June 17, 2024

Re: D&B U Sell It at 401 Unser Blvd. and 8530 Bluewater Rd. NW
Erosion and Sediment Control Plan
Engineer's Stamp Date: 6/14/2024 (K10E066)

Based upon the information provided in your submittal, received on 6/17/24, the above-referenced ESC Plan is conditionally approved to be in the SWPPP for the purposes of a Grading Permit only. However, it cannot be approved for a Building Permit until the following additional information is provided.

LANDSCAPE PLAN

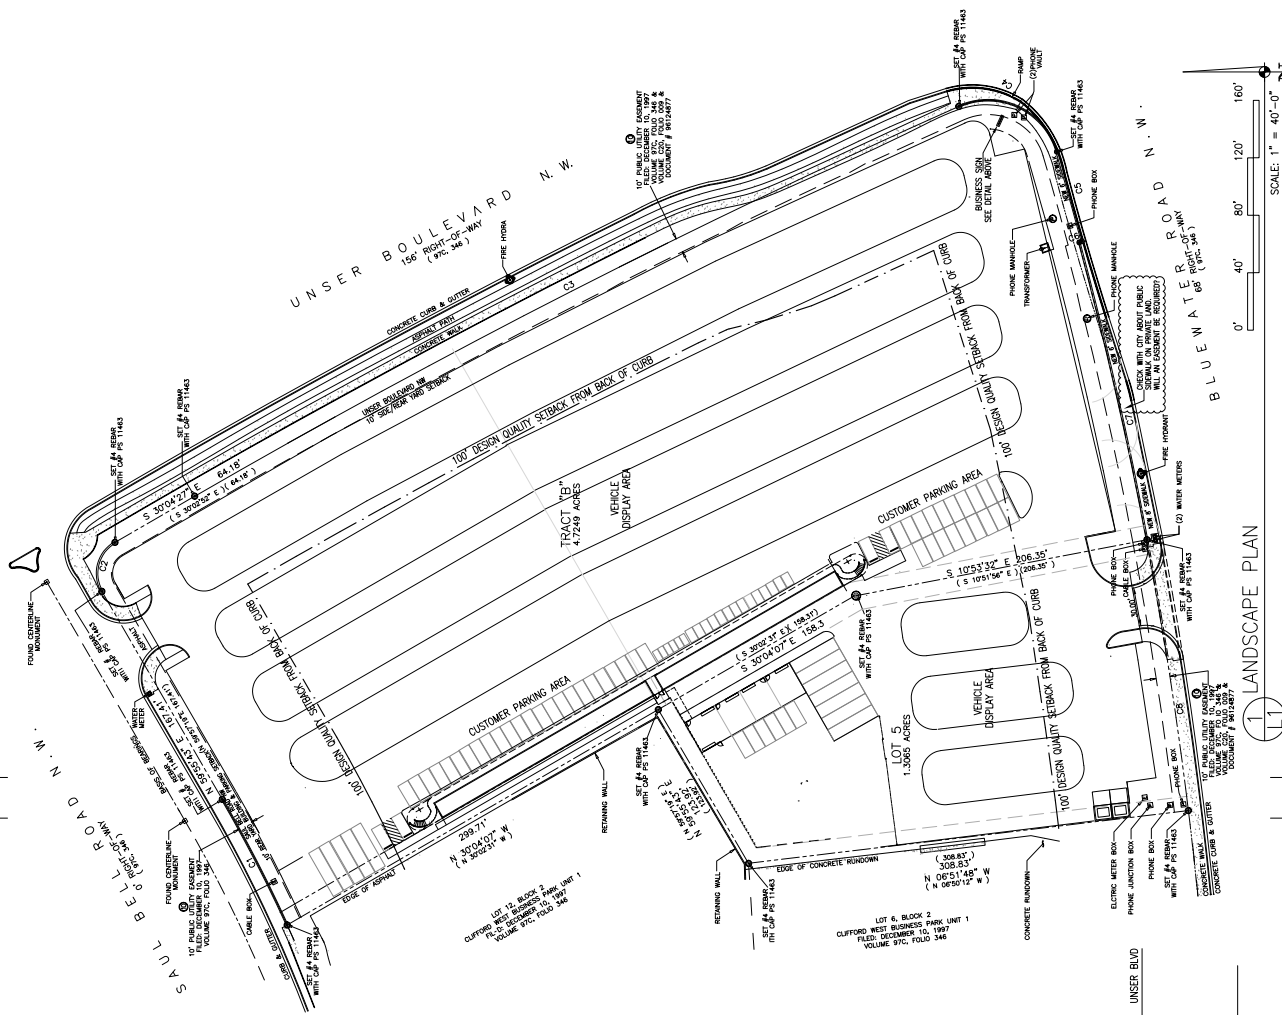
7. The SWPPP must include site-specific interim and permanent stabilization per CGP 9.6.1.c.i. The Landscape Plan can satisfy this requirement. It should be stamped and signed by a registered professional landscape architect, submitted separately from the ESC Plan with the application to the Stormwater Quality Section of the Planning
